A38 Derby Junctions
TR010022
8.x Statement of Common Ground with
Euro Garages Ltd

**A38 Derby Junctions
Development Consent Order 202[]**

**Statement of Common Ground
Euro Garages Ltd**

Drawing Title  
FIGURE 2.6  
MARKEATON JUNCTION  
GENERAL ARRANGEMENT

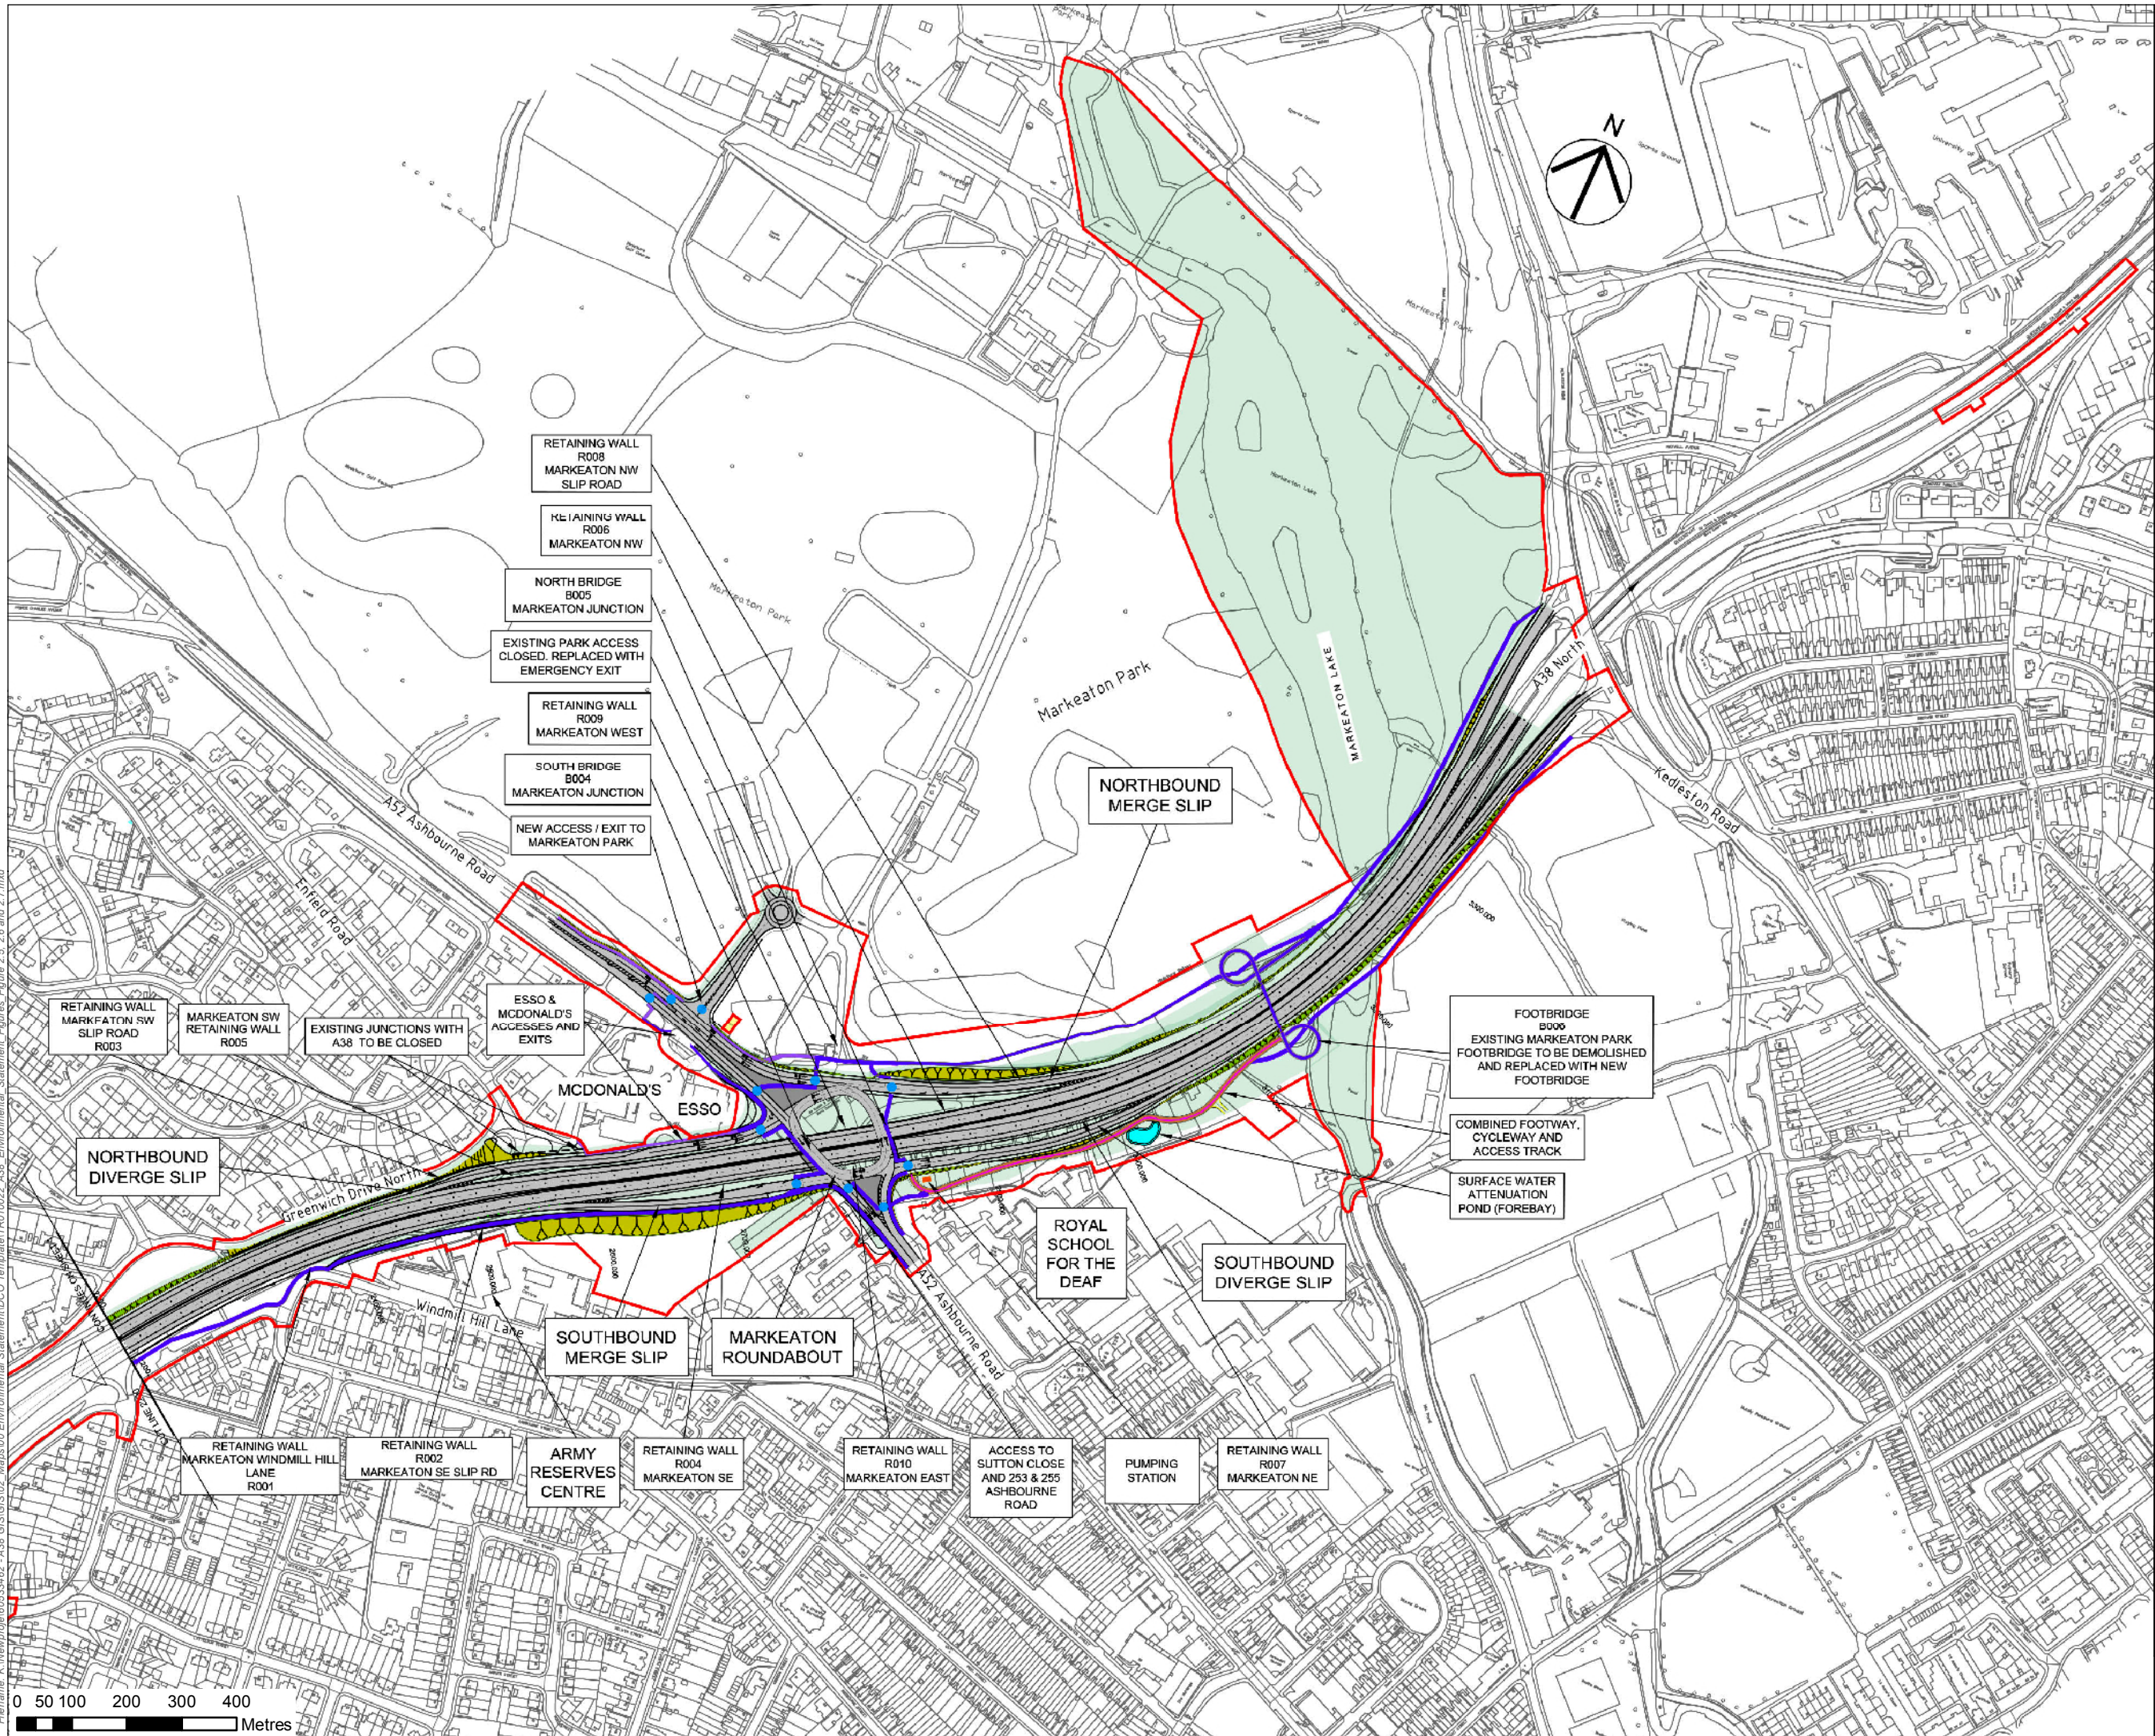
Issue reference (see Appendix A)	Document	Paragraph Ref	Sub-section	Comment	Highways England Response	Status
Issue ref: I.1, access and economic impact	Written Representation Comments	-	-	As readily accessible facilities [the service station], passing motorists can visit them without the need to depart from the strategic road network towards the town centre in search of services. The proposed scheme will have a serious and adverse effect on the trading operation of the service station. Petrol filling stations are trade related properties and trading performance is directly affected by certain key factors including accessibility and prominence to substantial traffic flows. The effect of the Scheme will be to allow traffic on the A38 to freely flow underneath the junction. This critical source of north and southbound trade will be lost to the service station, although this loss would be partially mitigated if advanced warning signs were provided as part of the scheme.	<p>Euro Garages' concerns regarding the potential loss of trade is noted.</p> <p>Highways England is currently investigating how/whether the combined site (Euro Garages and McDonald's) can be designated as a Trunk Road Service Area (TRSA). TRSAs can be signed as 'services' directly from the Trunk Road network.</p> <p>Progress on this issue will be reported in updates of this SoCG.</p>	Under discussion

Issue reference (see Appendix A)	Document	Paragraph Ref	Sub-section	Comment	Highways England Response	Status
				Highways England has yet to determine whether such signage could be provided.		
Issue ref: I.1, access and safety	Written Representation Comments	-	-	The scheme will also seriously reduce the accessibility to the site for traffic that continues to use the junction through interference with existing access arrangements, including works of stopping up and modification of accesses. We have further concerns over the Scheme in relation to the access arrangements that are currently proposed within the Scheme, in substitution of the existing access arrangements, because of their adverse effect on essential safe fuel delivery arrangements and access for HGV traffic.	The site will continue to enjoy entry and exit arrangements with the A52. The existing entry and exit arrangements with the A38 are to be modified to exit only (onto the proposed A38 slip road) for safety reasons. It is envisaged that fuel delivery will continue as it does at present, i.e. the tanker will enter the site from the A52 and will leave the site onto the A38 slip road.	Under discussion

Issue ref: I.1, access and	Written Representation Comments	-	-	Additionally, Euro Garages Ltd property currently enjoys direct and satisfactory access to the public highways of both the A38	Currently it is necessary to cross land owned by McDonald's to gain access to the filling station from both the A38 and the A52.	Under discussion

Issue reference (see Appendix A)	Document	Paragraph Ref	Sub-section	Comment	Highways England Response	Status
economic impact				<p>and A52 without the need to cross land in third party ownership. Unless the orders make provision for continued direct and satisfactory accesses that would allow the effective use of the service station in commercial terms, Euro Garages Ltd property would be further and unnecessarily depreciated in value.</p> <p>Additional Comment on Highways England's Statement</p> <p>The statement that the proposed scheme will not change these existing arrangements is not accepted on the basis of the preliminary investigations that have been undertaken on behalf of Euro Garages Limited.</p> <p>These investigations, which have involved producing a draft</p>	<p>A check with the land registry confirms that there are appropriate rights, by way of a conveyance dated 1982 to allow those who need to access the filling station to cross the land owned by McDonalds which abuts the highway at any time, day or night.</p> <p>The proposed scheme will not change these existing arrangements.</p>

Issue reference (see Appendix A)	Document	Paragraph Ref	Sub-section	Comment	Highways England Response	Status
				<p>overlay plan, illustrate that the documentary rights of way referred to in Highways England's response will be interfered with as a consequence of the scheme. Whilst the detail needs to be verified through detailed site survey to check the overlays, it appears that the proposed scheme will involve access over land lying outside the existing rights of way which is not within the control of Euro Garages Limited. If detailed investigation confirms this position, the adverse consequences on the operation of the service station and the resultant depreciation in value are likely to be significant. Euro Garages Limited considers that it would be possible for Highways England to ensure that appropriate rights of way can be made available to accommodate these issues and mitigate the adverse effects of the scheme.</p>
